DEPARTMENT OF PUBLIC WORKS

MEMORANDUM

SUBJECT: SPF 20-00004 Big Creek 2 (Santa Short Plat)

**BIG CREEK II SHORT PLAT, SP-19-00003**  
 A PORTION OF THE SW1/4 OF SECTION 21, TOWNSHIP 20 NORTH,  
 RANGE 14 EAST, W.M., KITTITAS COUNTY, WASHINGTON

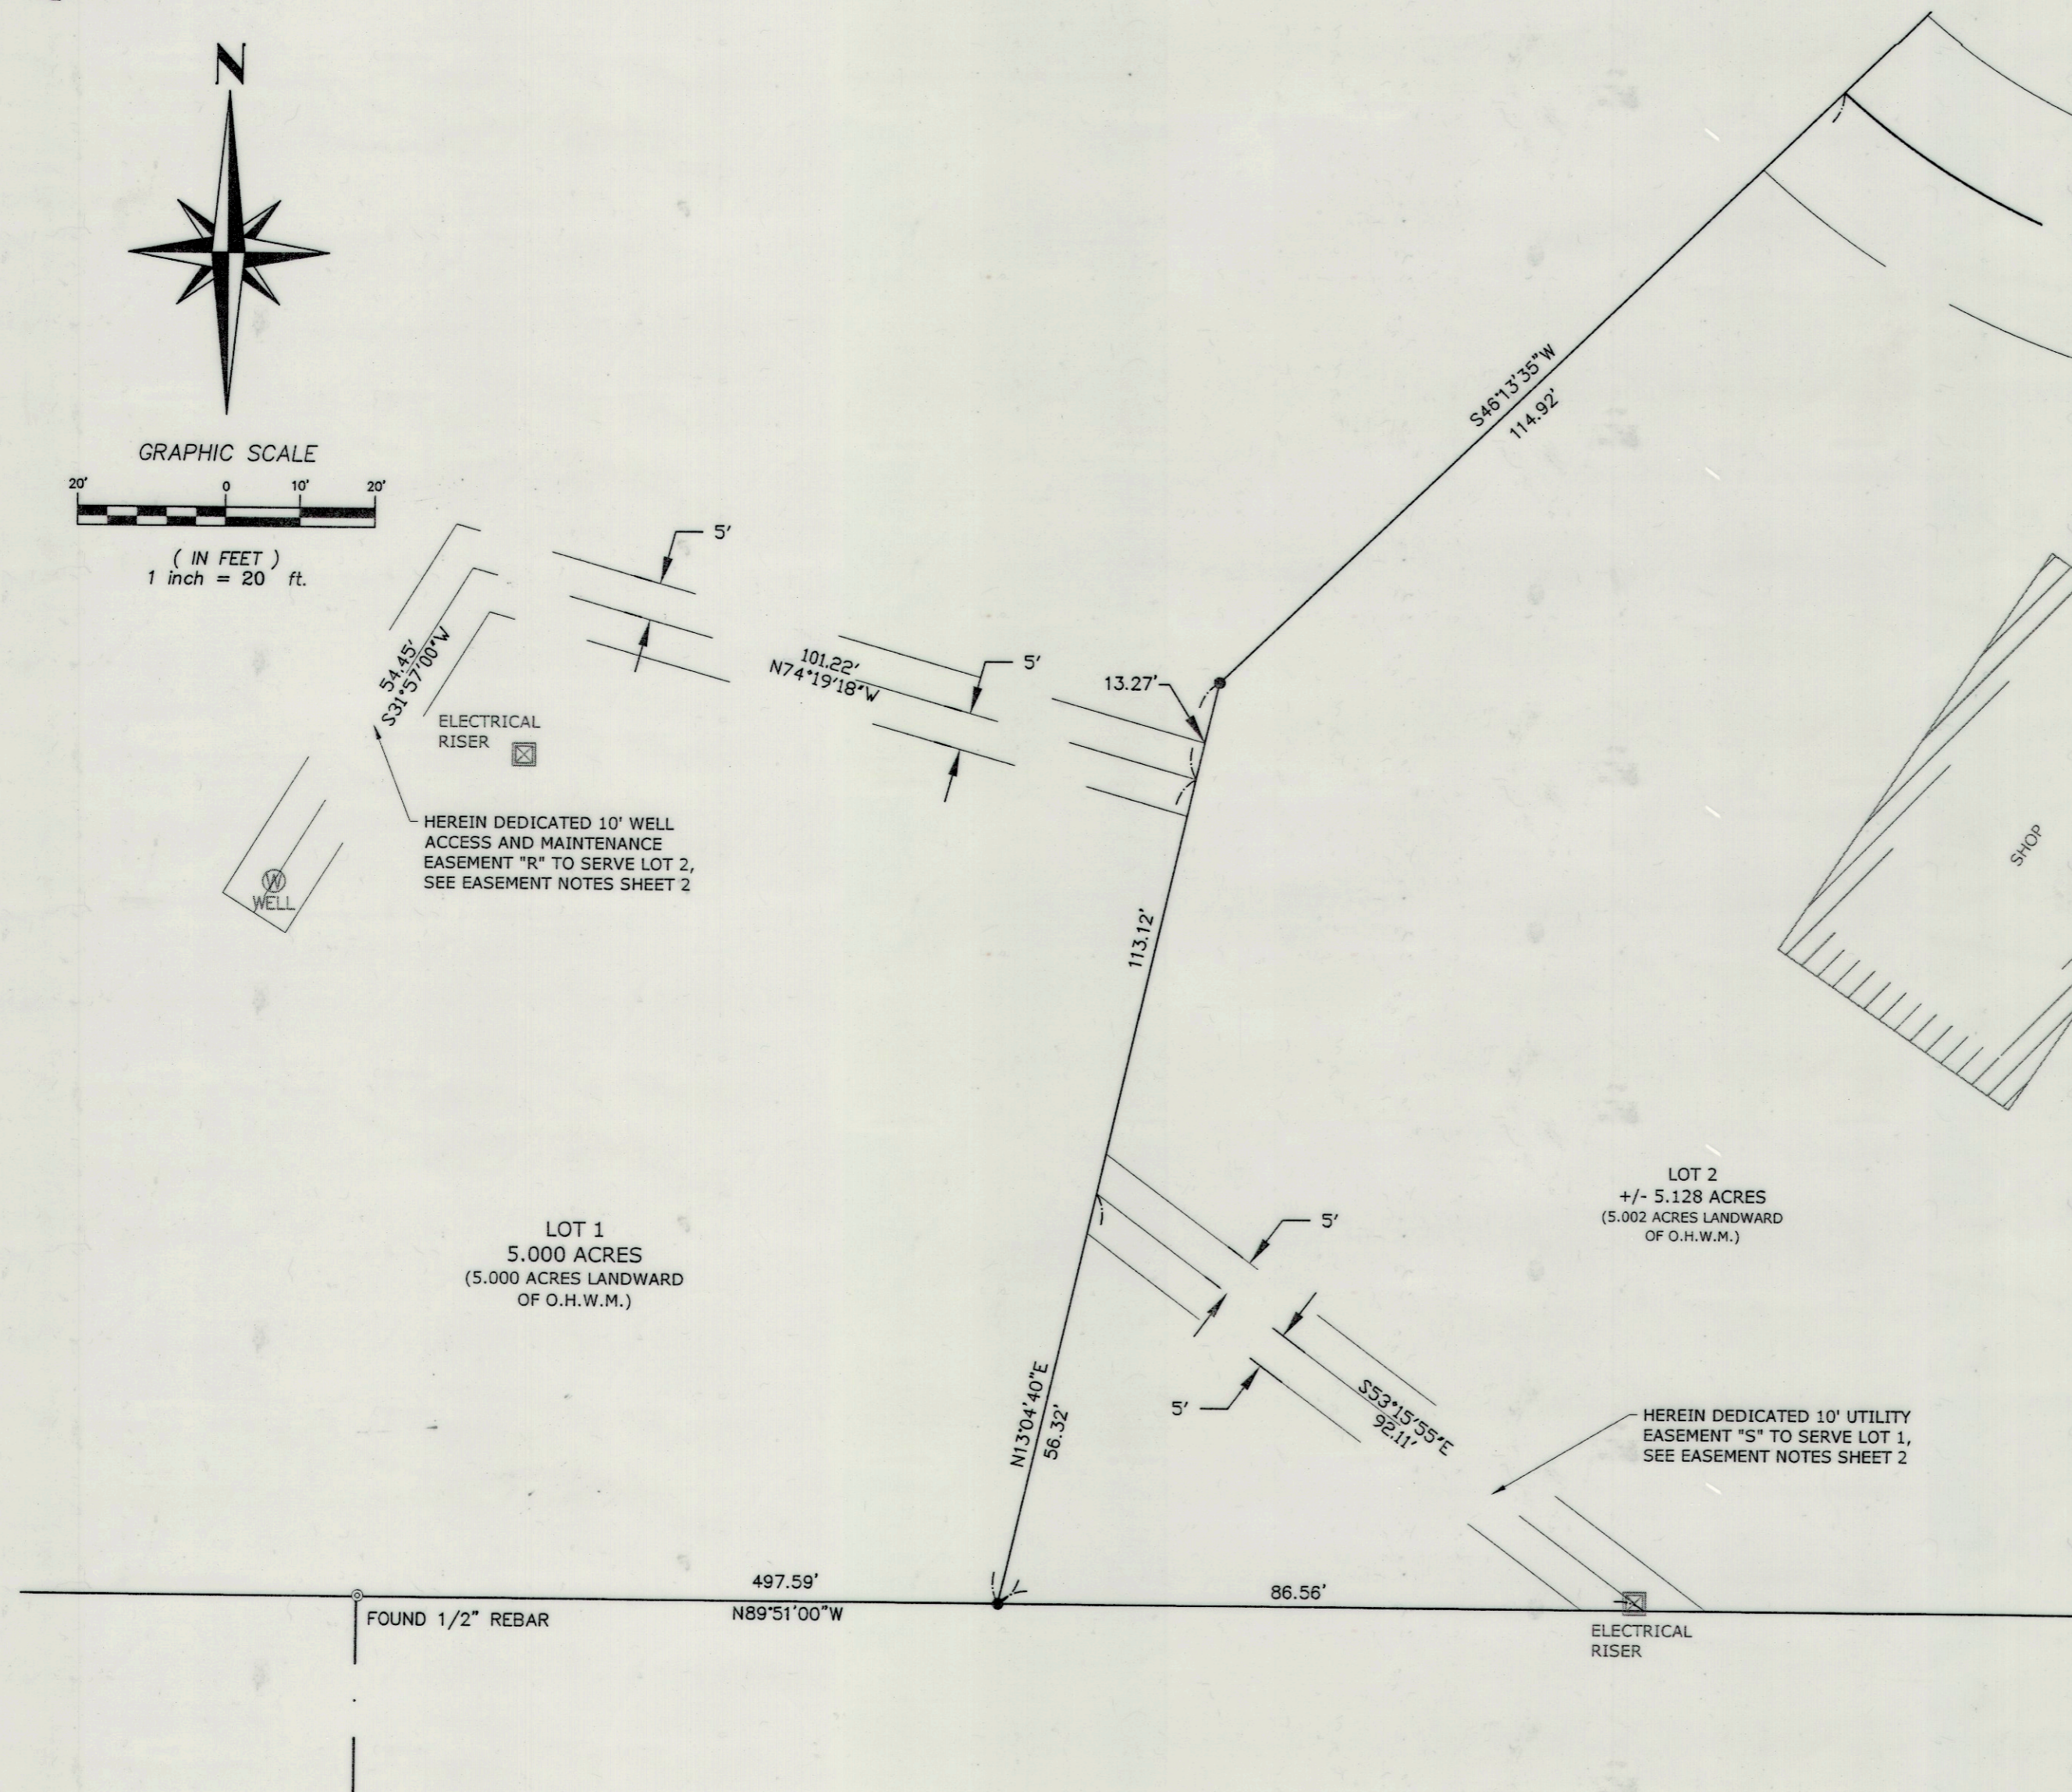
4. Access: The existing access easement from the Schmaus No. 4 Plat shall be constructed to joint use driveway standards to serve lots 1 & 2 of the Big Creek II Short Plat. Any additional lots accessing the easement may trigger additional county road standards at that time.
